TECHNICAL NOTE

Project Name : Land South of B2233 Main Road and West of B2132 Bilsham Road

Note Title : Response to WSCC Highways Comments

Date : 06/03/2018

Job Title		Client	
LAND SOUTH OF MAIN ROAD, YAPTON		LANDLINK ESTATES	
Drawing Title		Scale	
ACCESSIBILITY PLAN		1:20,000 @A4	DEC 17
		Drawn MS	Checked TDM
		Job No 14-111	Drawing No FIGURE 2
			Approved RJH
			Rev

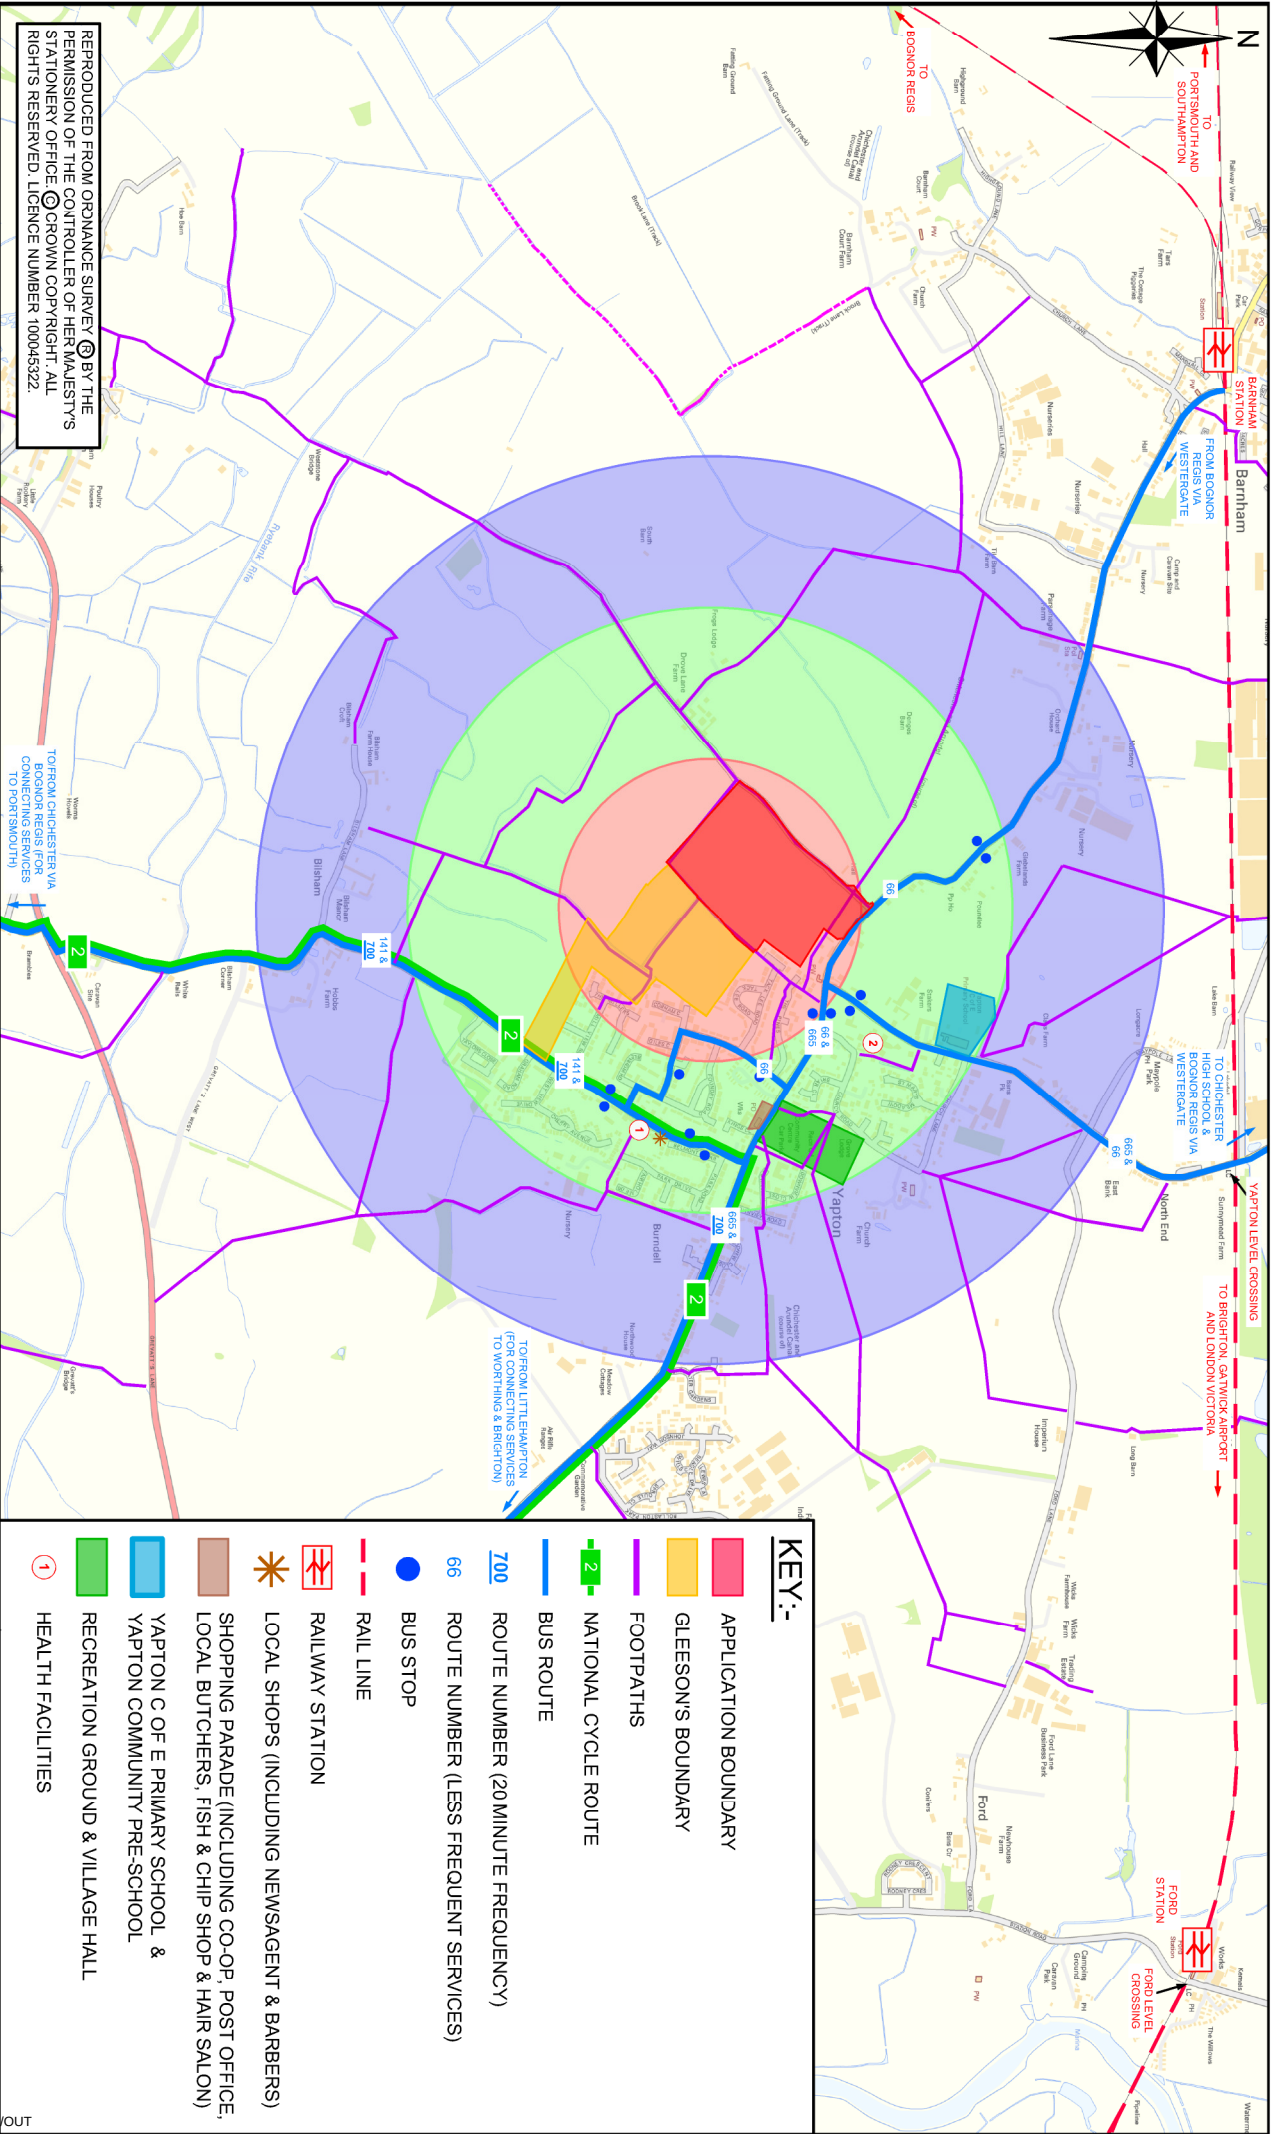
4.1 One of the objections raised by WSCC was *“The proposal would not achieve safe and convenient access by a choice of means of travel nor encourage and enable and increase in environmentally sustainable means of travel such as walking, cycling and public transport and thereby minimise the impact of car journeys.”*

- 4.5 Figure 2 of the submitted TA's illustrated the accessibility of both development sites (See **Appendix F**). As previously identified there are several points of access for pedestrians and cyclists.

- 4.6 The proposed accesses into the two sites will be from the B2132 Bilsham Road and the B2233 Main Road respectively and both accesses provide direct connections with the existing footways.

- 4.7 The B2132 Bilsham Road features 1.5 – 2m footway along both sides of the carriageway leading into the centre of Yapton, while the B2233 Main Road features a 1.5m – 2m footway along the northern site, to which connections will be available via an uncontrolled crossing.

- 4.12 The Public Right of Way (PRoW) leading from Tack Lee Road to the B2233 Main Road to which the development will provide connection is currently a narrow track with wide verge along both sides. Where this PRoW crosses the site, improvements will be provided to encourage walking and cycling.
